American Dog Pros of Colorado  
12900 Murphy Rd  
Elbert, Co 80106  
719 400-8553

March 1, 2022

This letter is a request to update the current site plan for American Dog Pros, 12900 Murphy Rd, Elbert, Co. There is an existing major dog kennel business at this property. This property is owned by IC4/Chris Dunlap 719 287-1449, [chrisdunlap.03@gmail.com](mailto:chrisdunlap.03@gmail.com). Current update includes new structures: barn, greenhouse, perimeter fencing, a walking path and a gazebo all personal/agricultural use. 4 parking spaces, refuse bins and enclosure, a sound barrier fence, a fenced training yard, 2 - 4'x10' vinyl signs will be business use.

Footprint of all existing and proposed buildings and the setback distances from each existing and proposed structure to the property lines. No sidewalks.

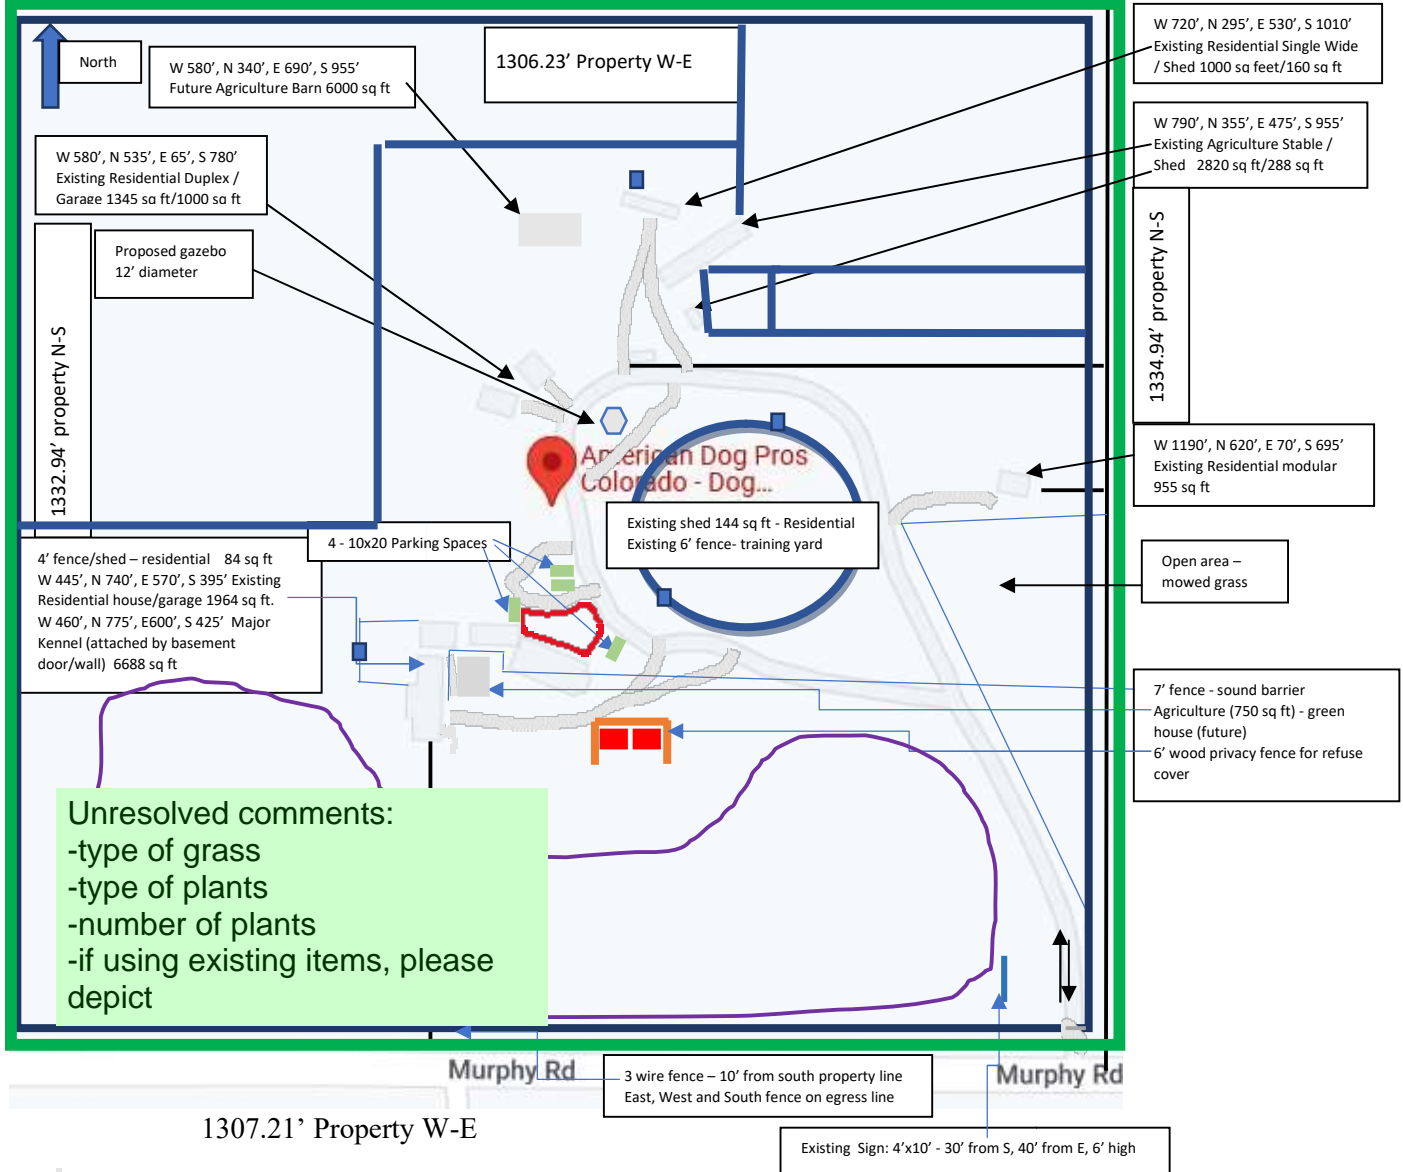
Current update or is the barn and greenhouse going to be submitted at a later date/separate application? Conflicts with "future" references on the site plan

9. Regarding F – this property is covered with evergreen trees. The area near the main entrances will have ground cover and plants in the spring.
10. Regarding G – this property exceeds the minimum trees for the boundaries. There are no refuse areas, loading docks, or curbs within view of the main entrances. Any disturbed areas will be replanted in the spring. This is a remote, rural area. There are no water storage places or outside storage areas. Provide a discussion regarding "future landscape"

Conflicts with "future" references on the site plan

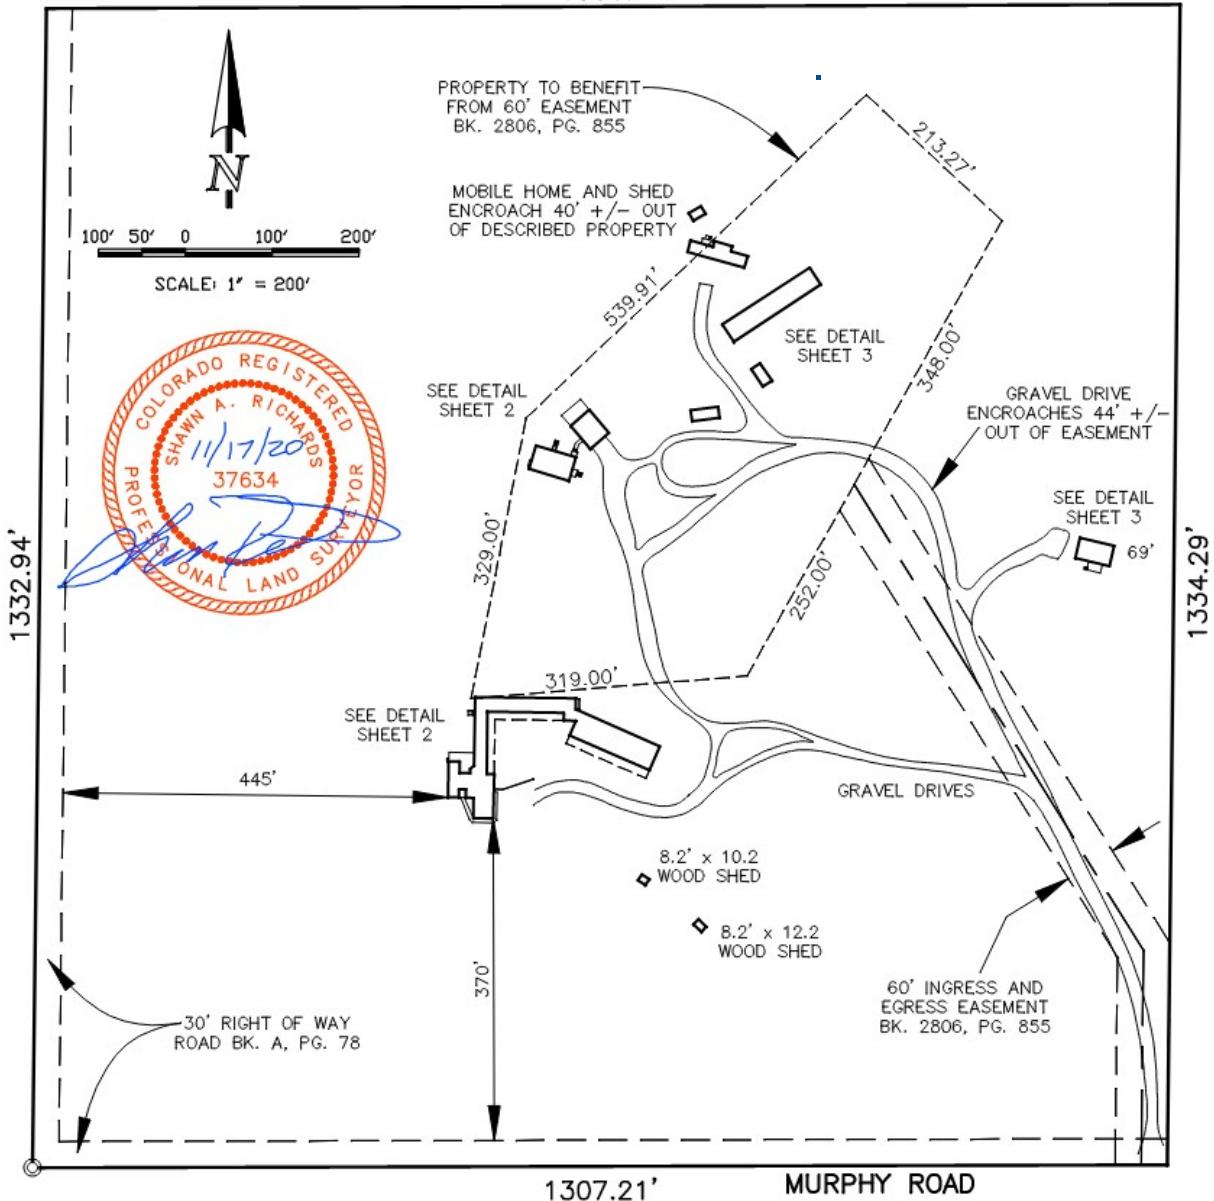
ADA note shall be added to the site plan, and an ADA path shall be shown on the plan. See comment on the site development plan

American Dog Pros Sign Plan

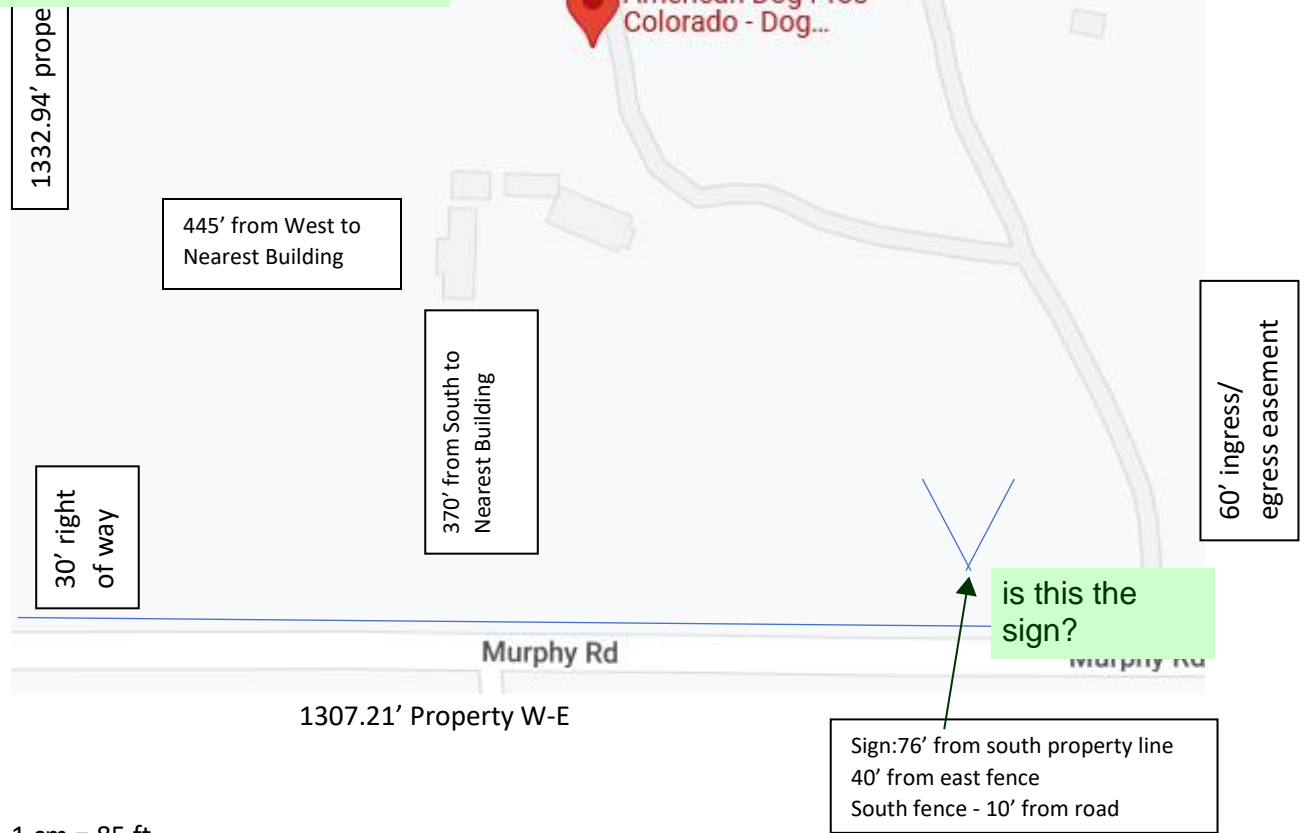
Are these signs new? Or have they been previously approved and are existing? Conflicts with site plan calling out "current".
